# KITTITAS COUNTY

### MEMORANDUM

**TO:** All Staff  
**FROM:** Public Works Plan Review Team  
**DATE:** February 12, 2026- UPDATE March 16, 2026  
**SUBJECT:** BL-26-00001 Fields

RECORD OF SURVEY

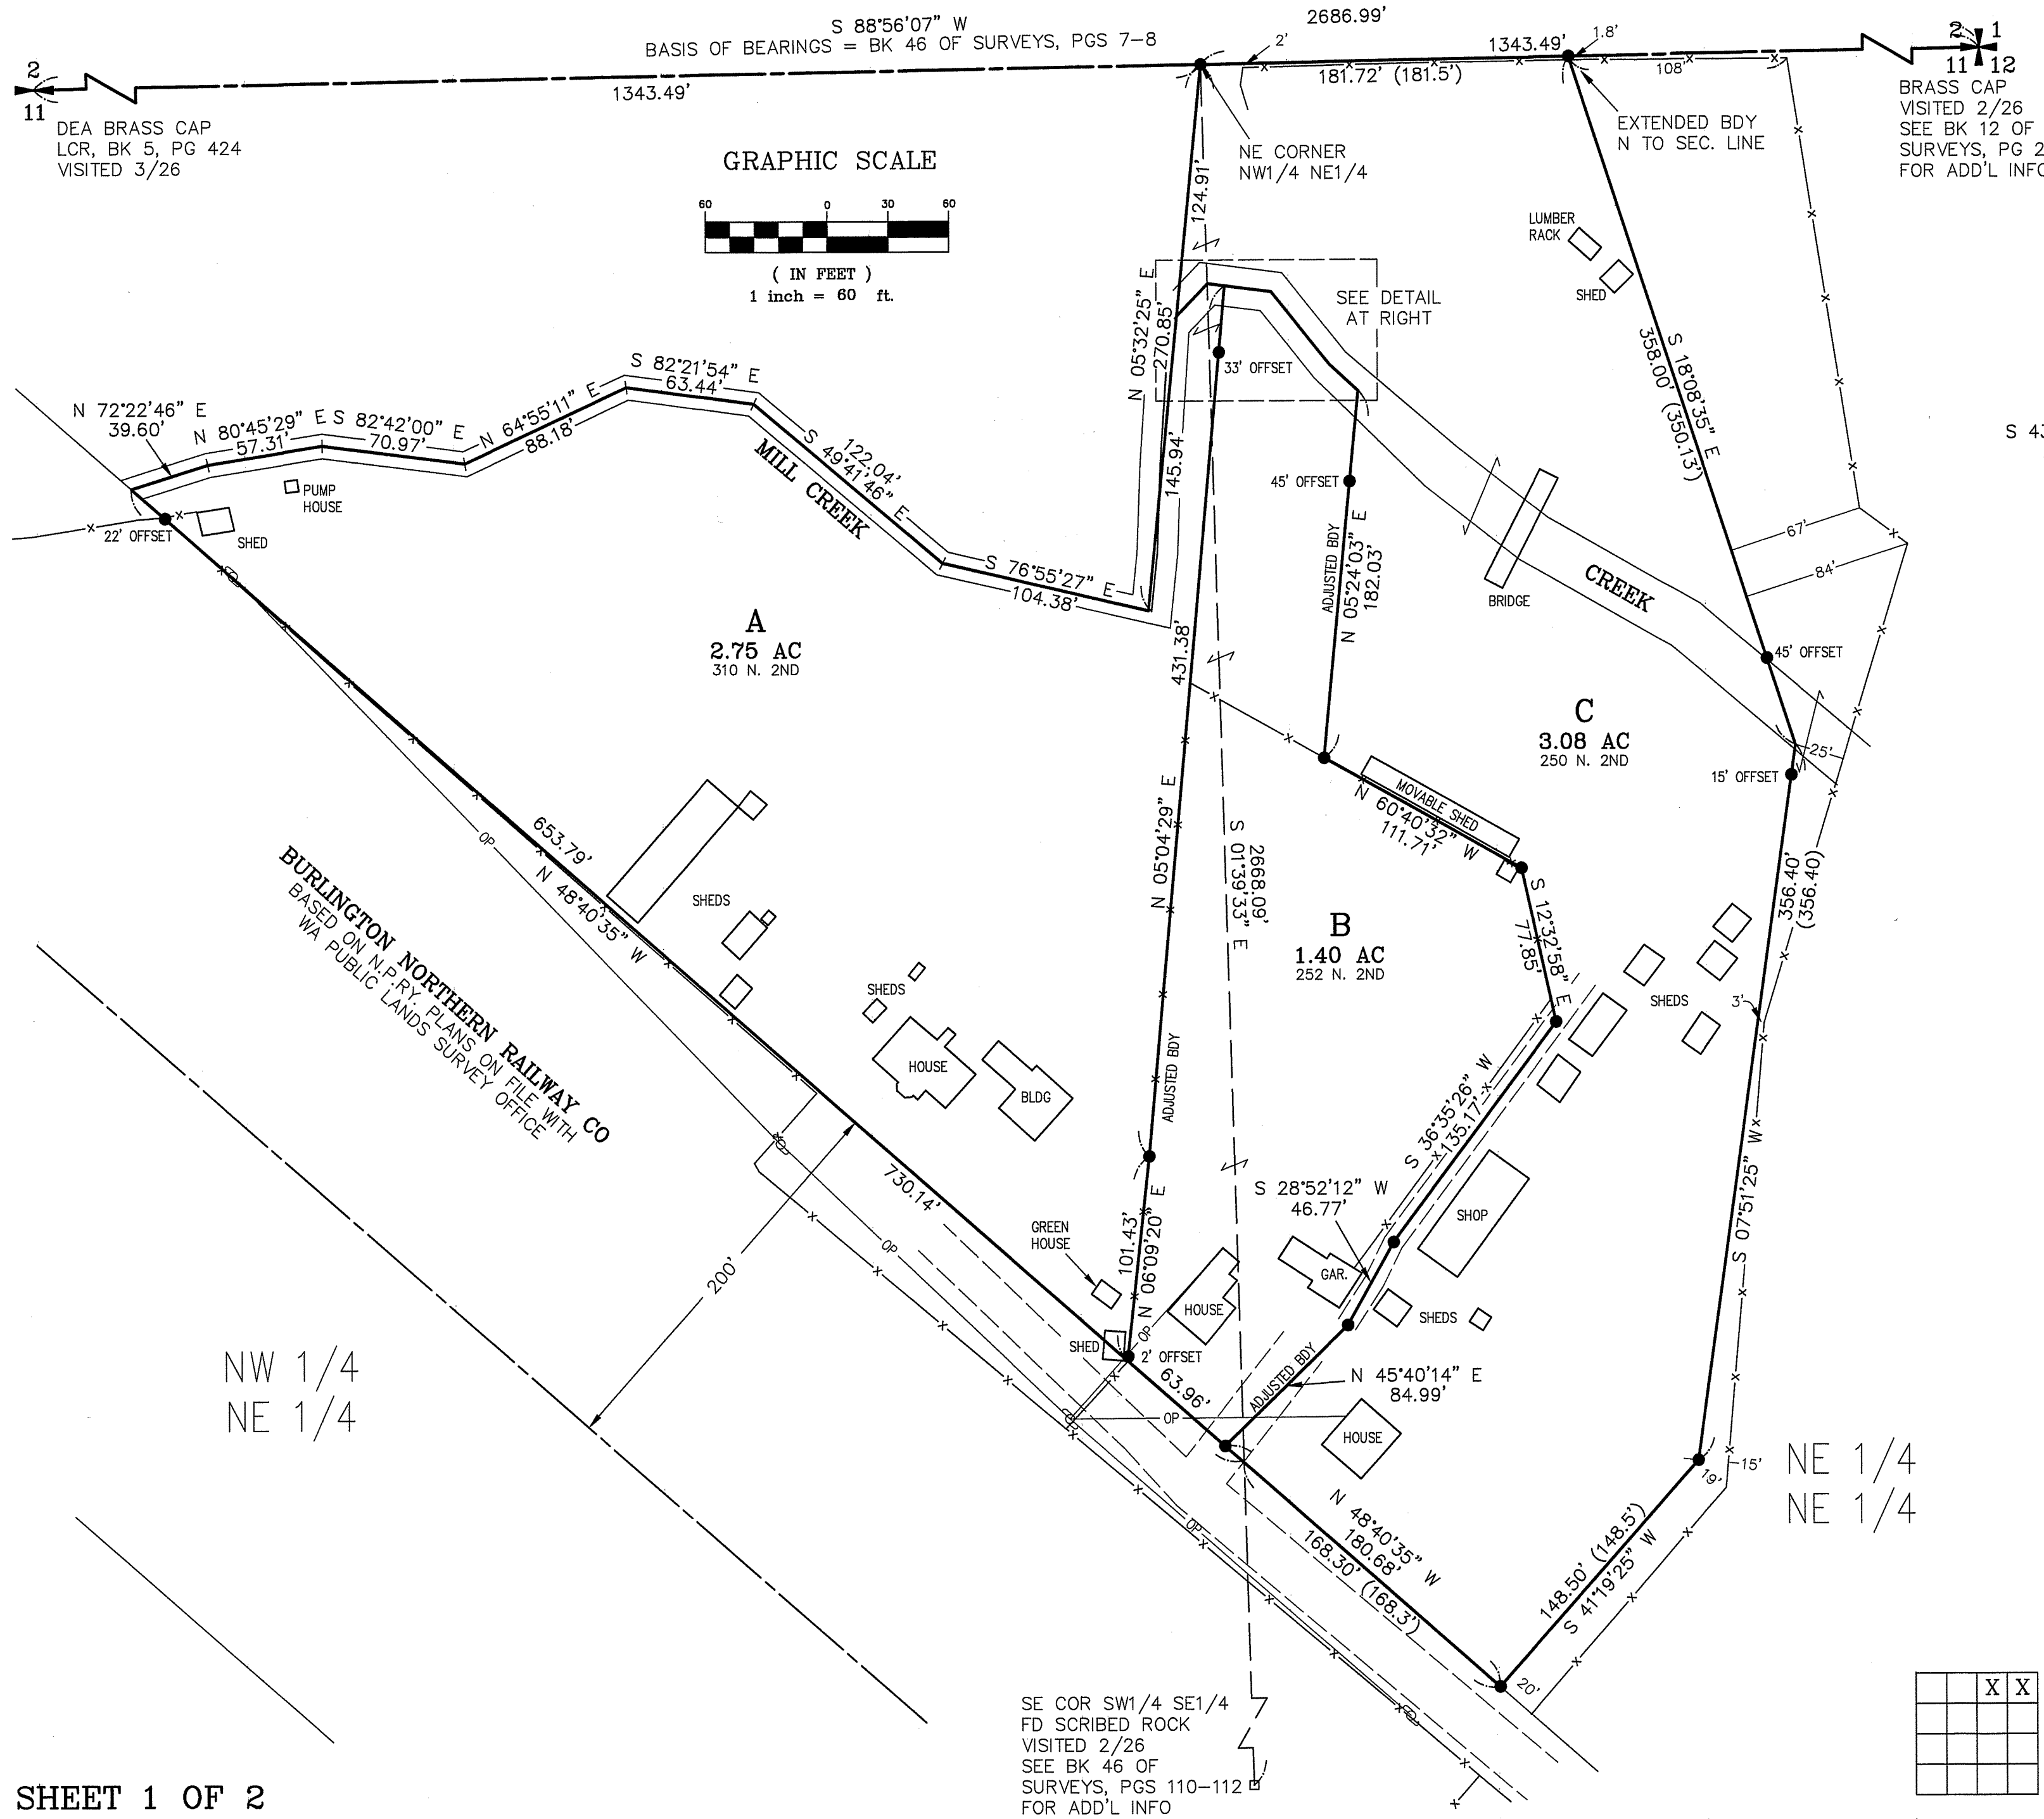
<b>ACCESS</b>	<ol style="list-style-type: none"> <li>1. An approved access permit shall be required from the Kittitas County Department of Public Works prior to creating any new driveway access or altering an existing access.</li> <li>2. Maintenance of driveway approaches shall be the responsibility of the owner whose property they serve. The County will not maintain accesses.</li> <li>3. Any further subdivision or lots to be served by proposed access may result in further access requirements. See Kittitas County Road Standards.</li> <li>4. Provide proof of easement for shared driveway access to lots prior to final approval.</li> </ol> <p>In addition to the above-mentioned conditions, all applicable Kittitas County Road Standards apply to this proposal. Access is not guaranteed to any existing or created parcel on this application</p> <p>OF NOTE:  Parcel 745933 to retain address 310 N 2<sup>nd</sup> St ; It is unclear which home will retain 250 and 252 N 2<sup>nd</sup> St on parcel 685933.</p>

<b>ENGINEERING</b>	<p>Except as exempted in KCC 14.05.060, no grading or filling upon a site involving more than one hundred (100) cubic yards shall be performed without a grading permit from the County Engineer or Public Works designee (KCC 14.05.050). An application for grading in excess of five hundred (500) cubic yards shall be accompanied by an engineered grading plan (KCC 14.05.080). (CBP)</p>
<b>SURVEY</b>	<p>As the application does not contain a survey map, comments are herein reserved until final. (JT)</p> <p>UPDATE 03/16/2026</p> <ol style="list-style-type: none"> <li>1. Please show previous boundaries. Dimensions are not required.</li> <li>2. Please label 2<sup>nd</sup> street as "2<sup>nd</sup> Street (County R/W-Gravel)" or similar. Identifying R/W width is not required.</li> <li>3. Please identify "End of County Road" at the Gate located near the shared corner of Lots A and B.</li> <li>4. For Lot A driveway within the railroad right of way, please note railroad licence, agreement OR note "access by prescription".</li> </ol>

5. Per WAC update, legal descriptions must include legal description AND document sourced from. Please include reference to Title Report, Deeds, or Records of Survey that the legal descriptions were obtained from. (JT)
<b>TRANSPORTATION CONCURRENCY</b>	No transportation concurrency management application is required for this project as described.
<b>FLOOD</b>	Parcels 675933, 685933, and 745933 are completely within the FEMA mapped special flood hazard area (1 percent annual chance flood zone). All development within the special flood hazard area requires a floodplain development permit, including structures that are exempt from a building permit, and must follow the guidelines within KCC 14.08. (SC)
<b>WATER MITIGATION/ METERING</b>	No comments. (SC)
<b>AIRPORT</b>	Proposed project is not located within the Airport Overlay Zone.
